West Sussex BN18 9HY - Planning Conditions

4 & 8

Condition 4 – Construction Plant and Materials

Condition 8 - Access

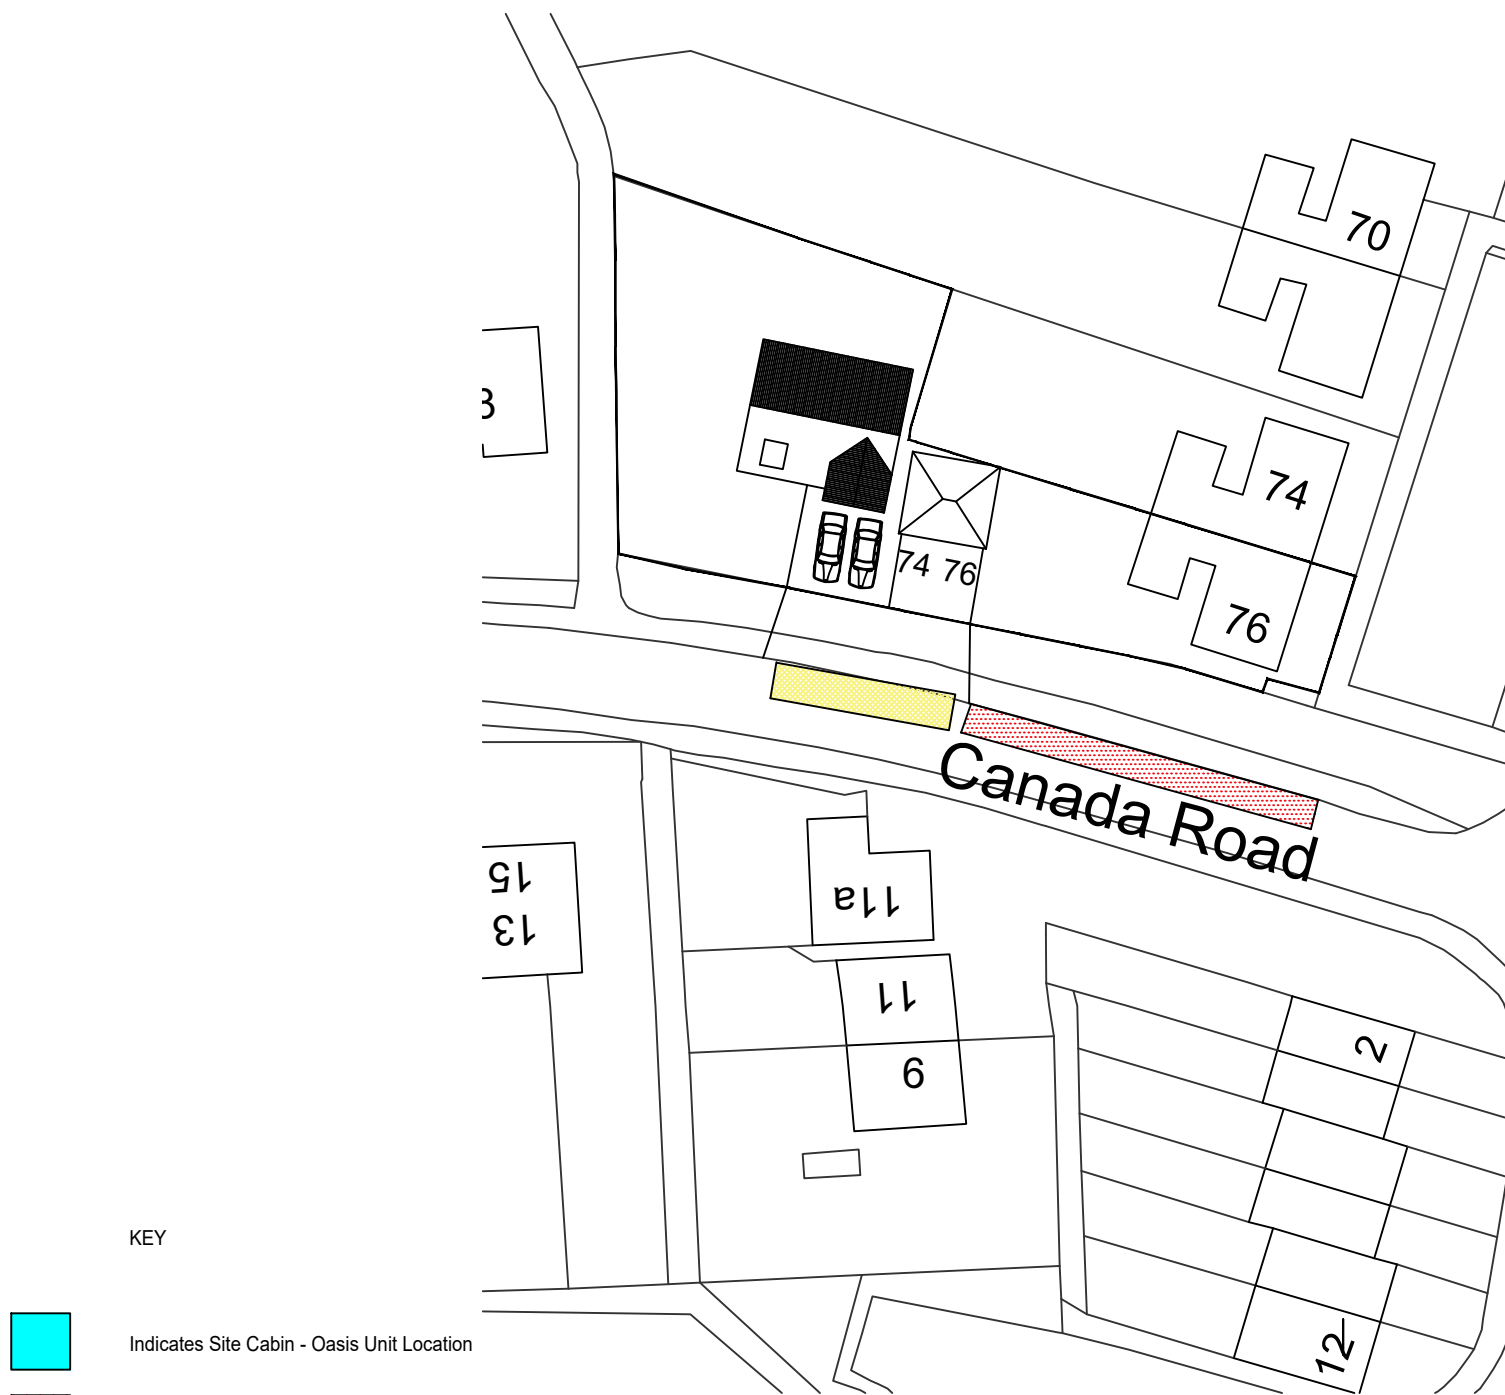
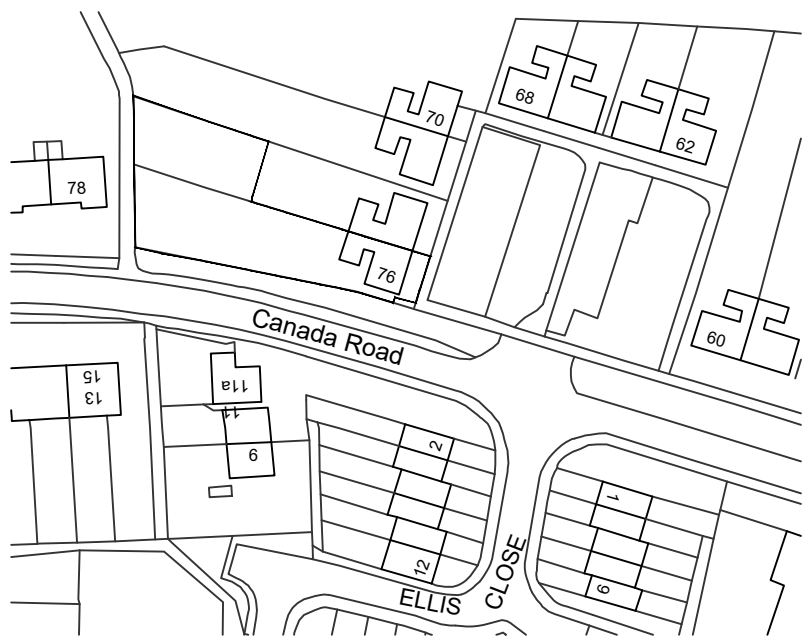
As per, and adding to Stephens comments 30th July WSCC. Parking by contractors can naturally take place on street while taking into consideration any existing traffic regulation orders. However it is not advised that a specific area for this is marked on discharge of condition plan. This is because the roads status as public highway is secured by statute and thus should be free for use by all. It would also restrict contractors to only parking in those specific locations when they may not be free.

This could be mitigated by way of a temporary traffic regulation order, but the applicant does not seem to be proposing this.

It would be better if a statement was made similar to “Due to the constraints of the site contractors will be required to park on street in a safe and considerate location. Any such parking must take into consideration any existing traffic regulation orders.

Similarly with materials storage, typically we try and avoid this if possible but it can be permitted with the appropriate licence agreement from WSCC Highways. Please can the applicant confirm if they do wish to store materials on the highway and I will enquire with the area office if ‘in principle’ such a licence would be forthcoming in such a location.

SWEPT PATH ANALYSIS WITH 6.4m CROSSOVER
(1:100)

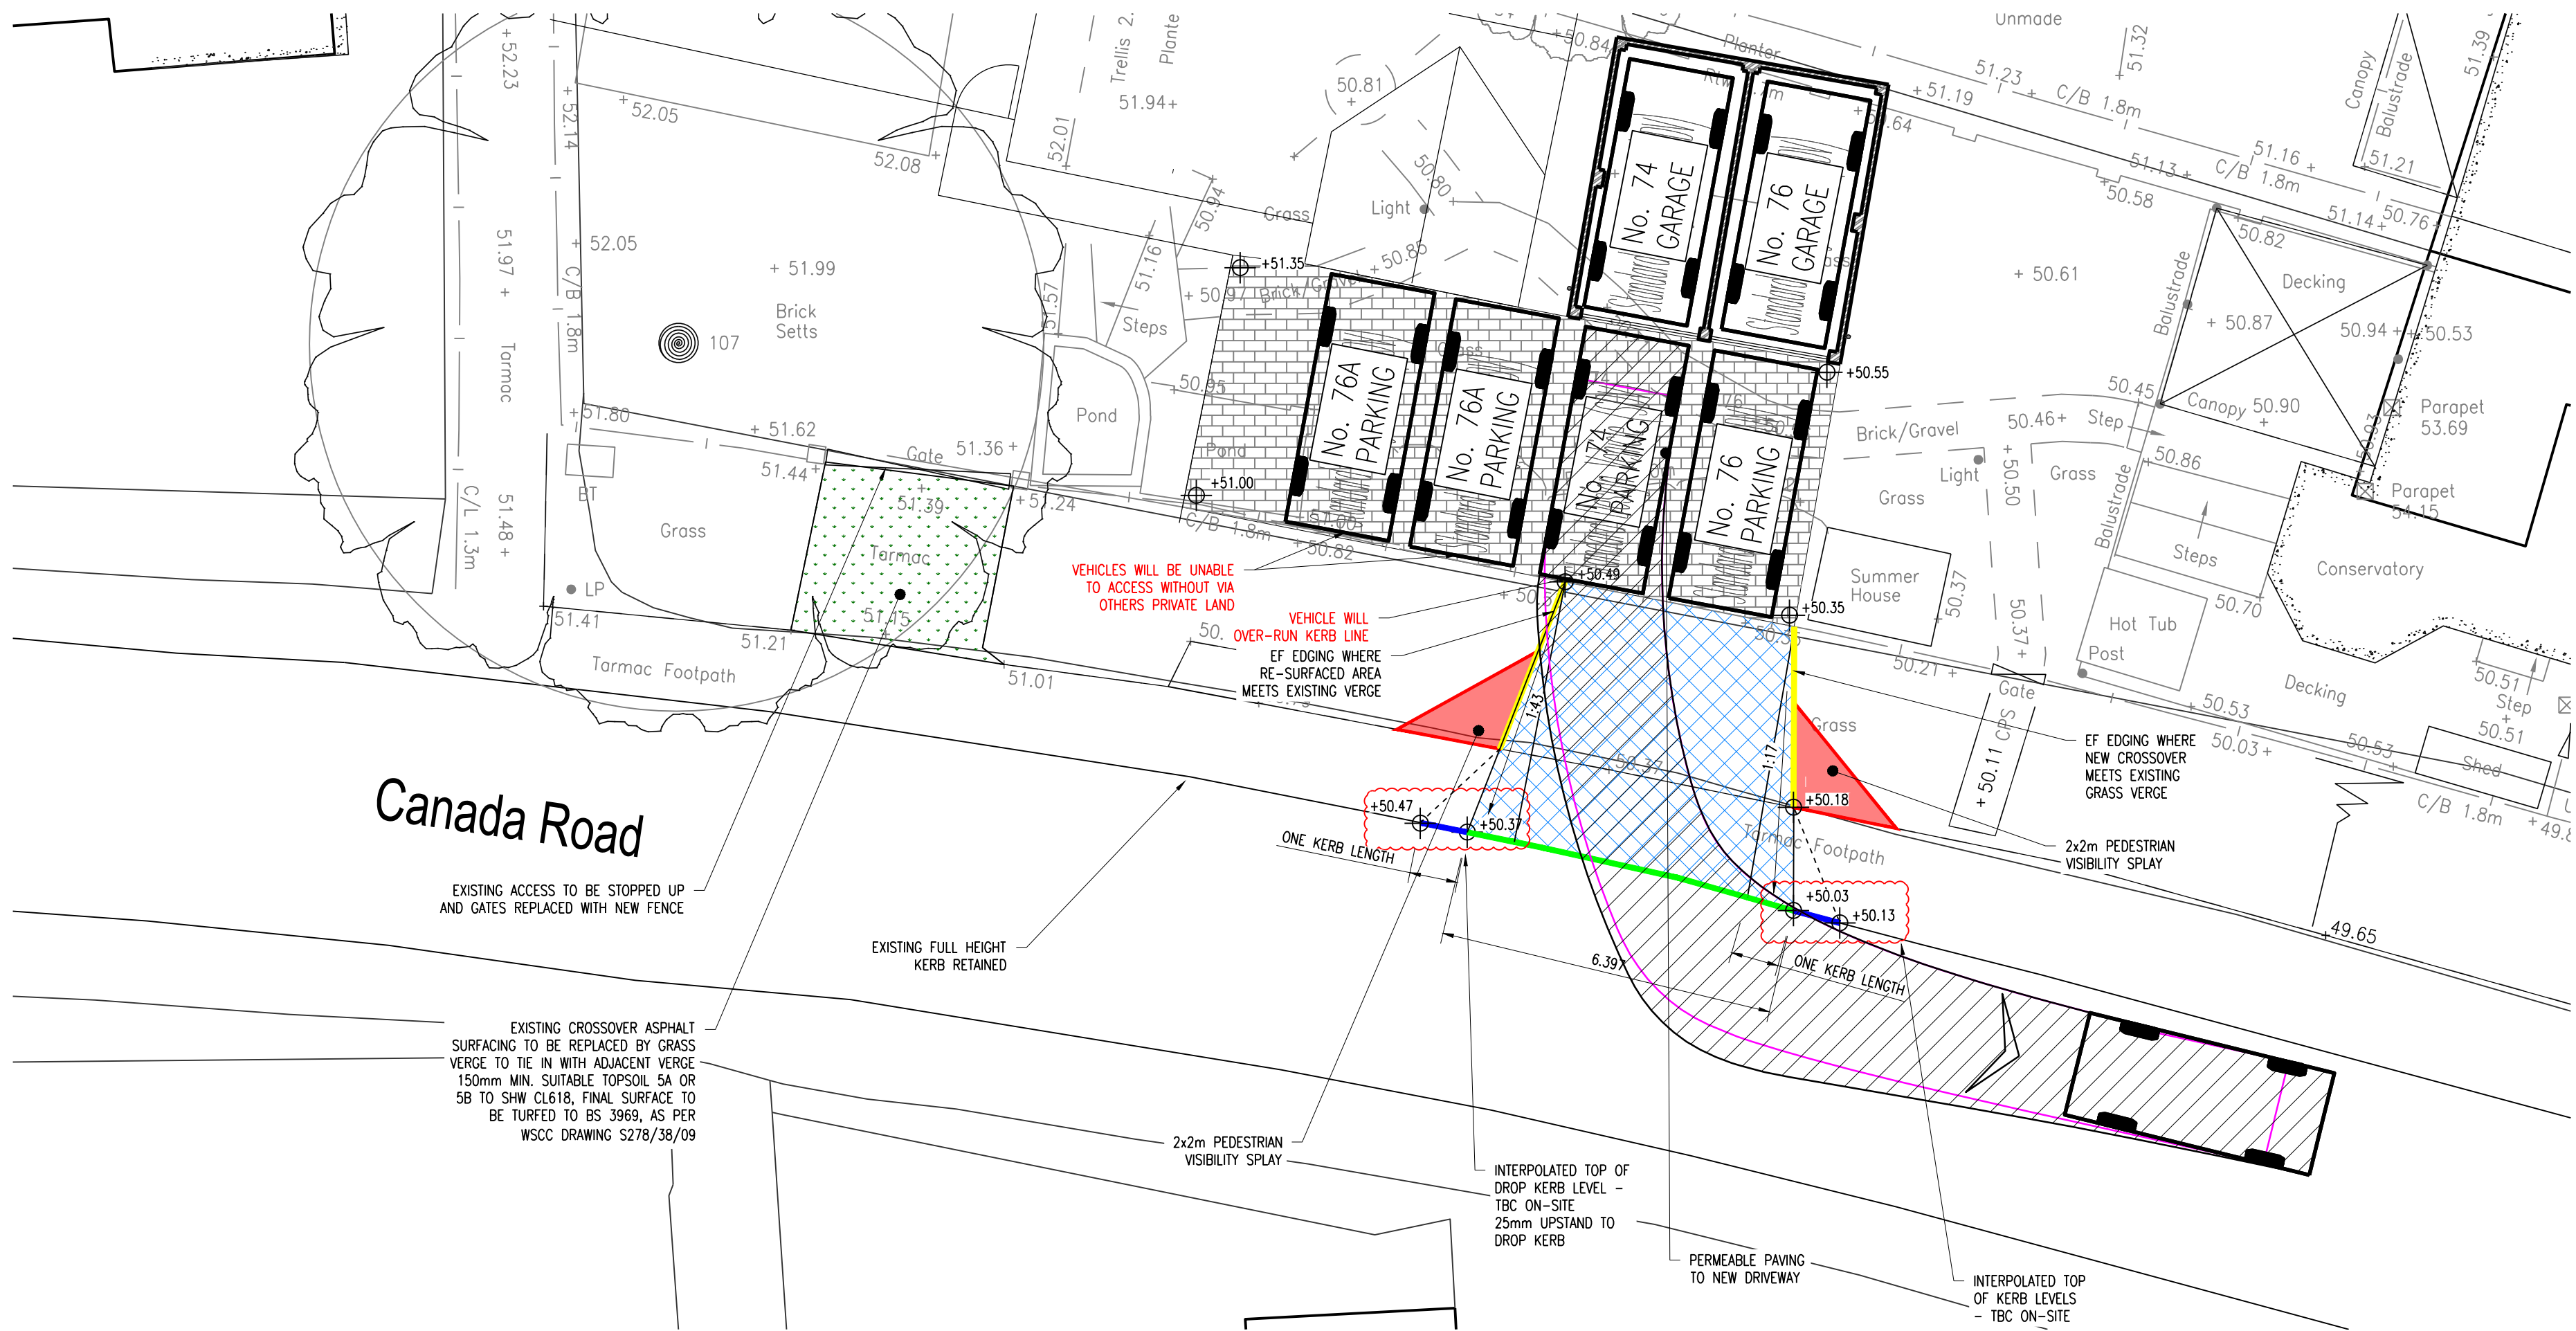
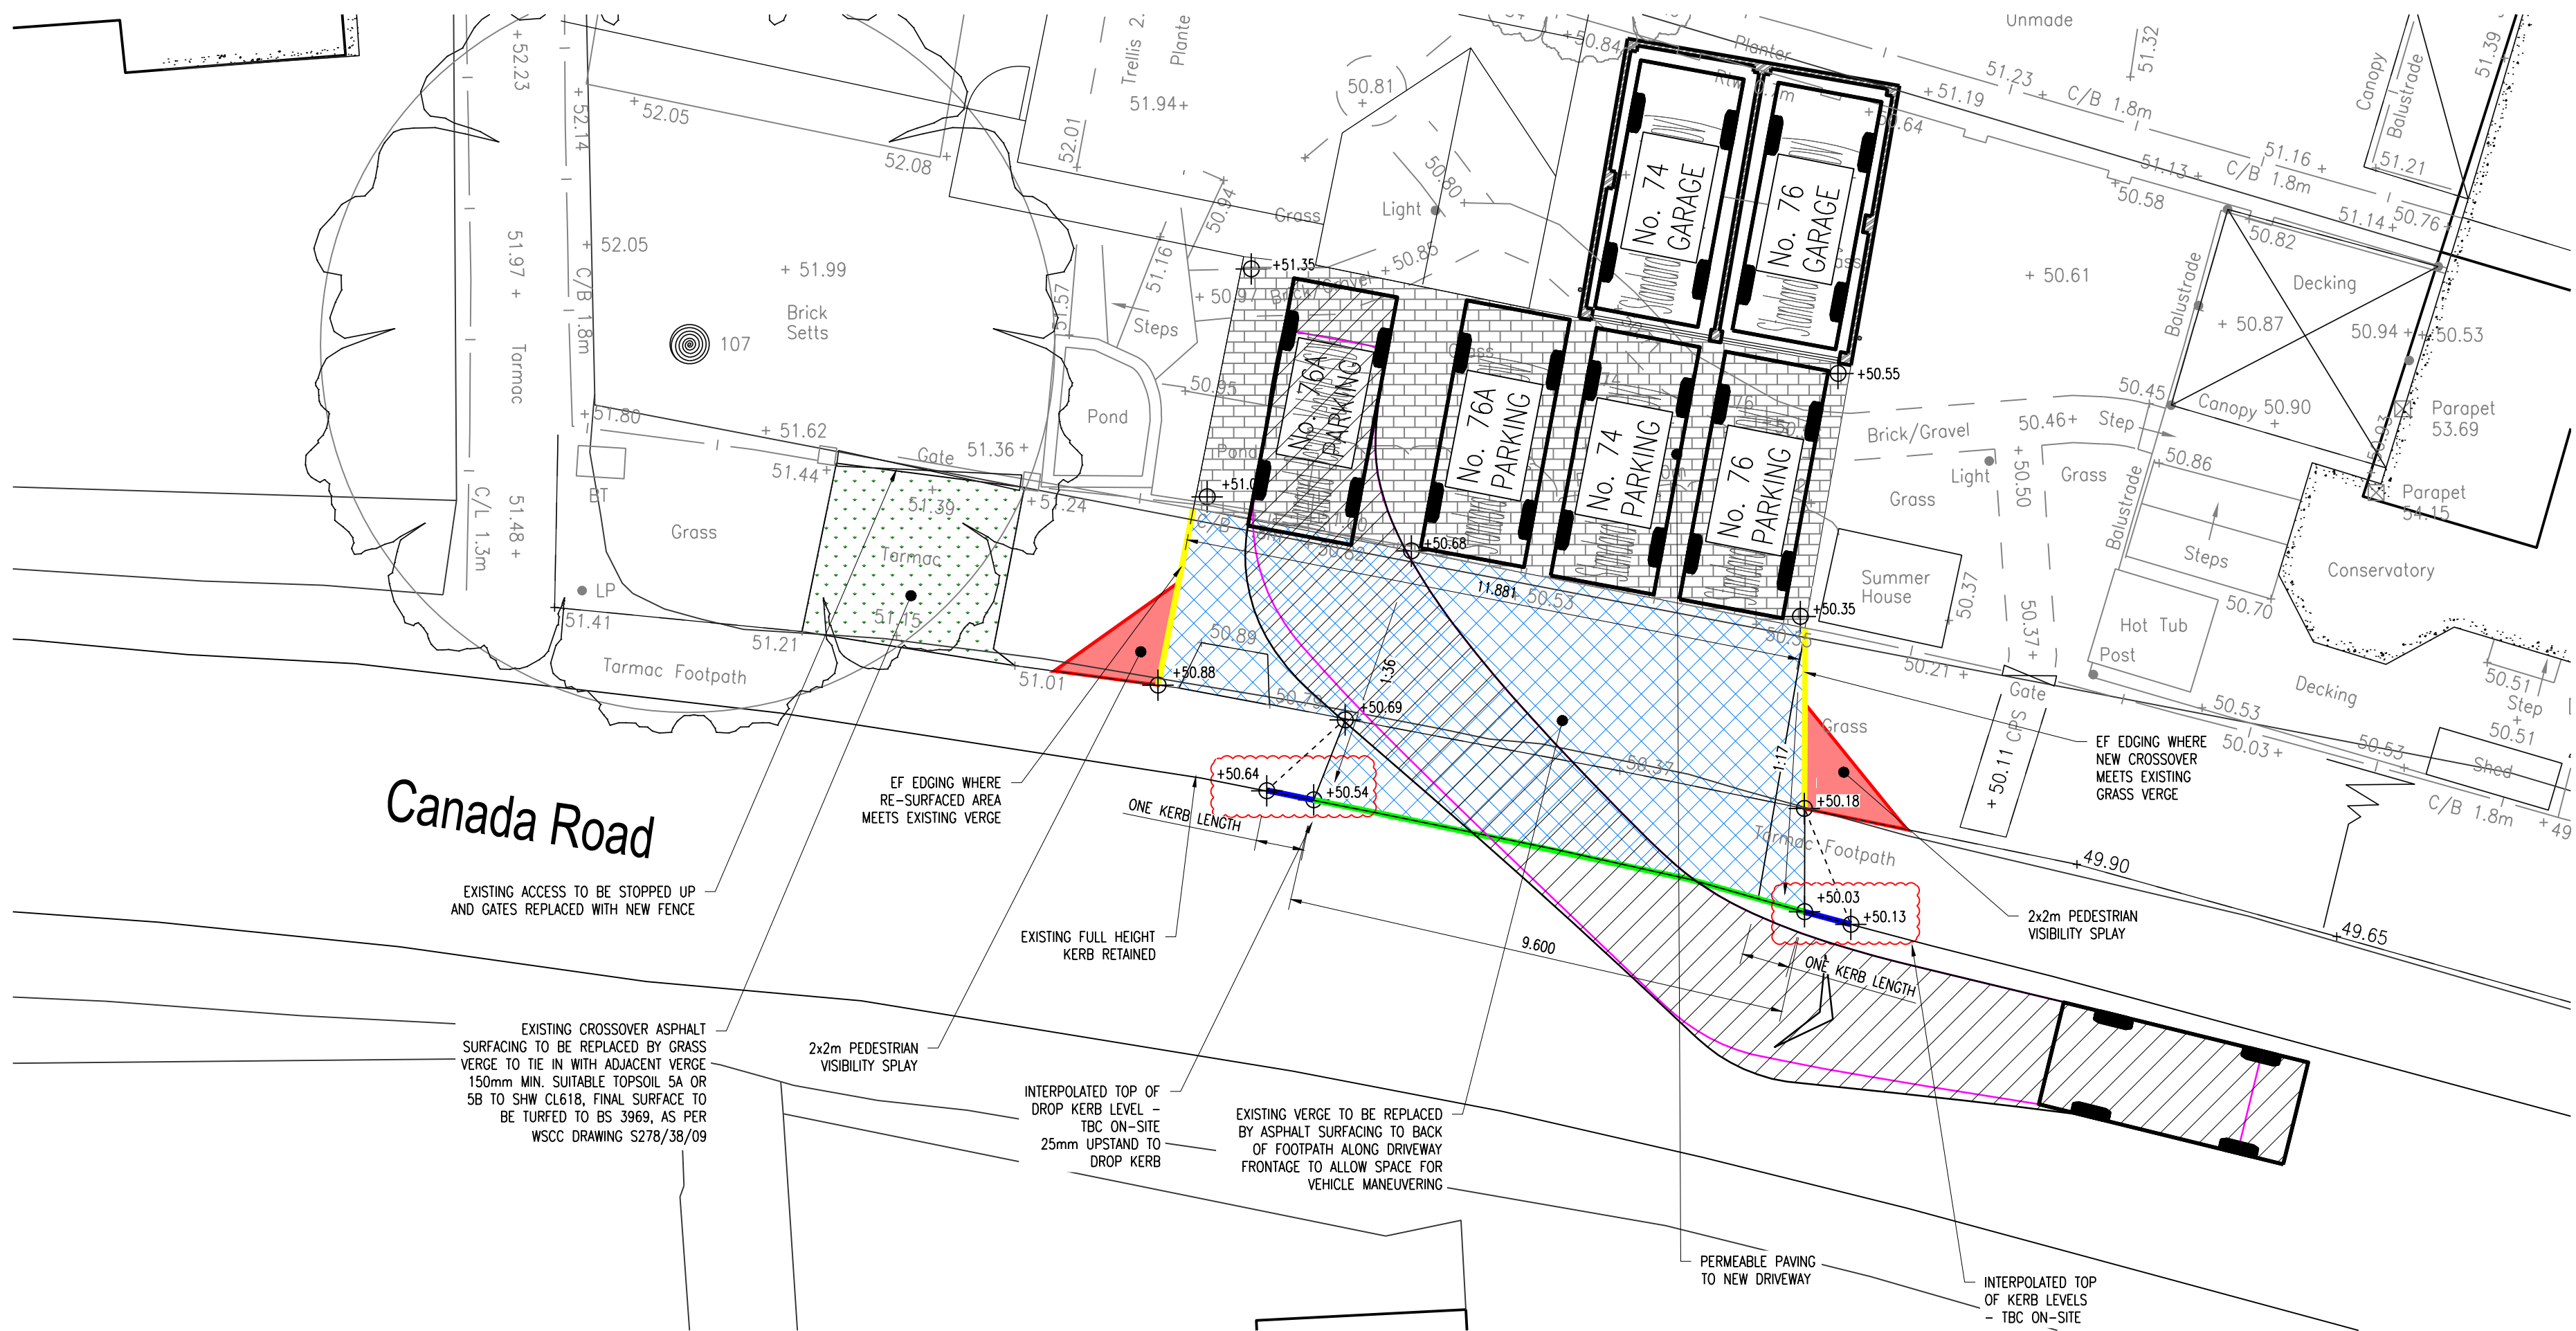
Am I right in thinking they have not submitted any plans that show a reduced width crossover at 6.4m wide? I can’t see such plans on the Arun Planning Portal or on the email string. The latest seems to be Plan 101A as attached to one of Glenns emails.

Glenn seems to be asking if a crossover width of 9.6 metres would be acceptable. I can see the logic behind this as it would allow for convenient access to the garage spaces and hardstanding for 74 and 76 Canada Road and allow for access to the proposed parking spaces for the new dwelling. To my mind a 6.4m wide crossover may limit accessibility for some of the spaces, though its difficult to say this with any certainty as that has not been demonstrated to date.

Our area office are resistant in granting licence application grater than 6.4 metres in width due to the loss of on street car parking provision. I think the only way forward is to present to the area office a plan that shows how a 6.4m wide crossover is not workable. I.e. showing a 6.4 crossover where it is then clear that vehicles accessing the new parking spaces will be required to bump the kerb in order to access the approved parking spaces. A similar plan showing a 9.6 metre wide crossover or greater can then be provided to show the minimum width required to provide a workable solution. This will then be materially different to what we have presented to the area office with to date to provide us a view on.
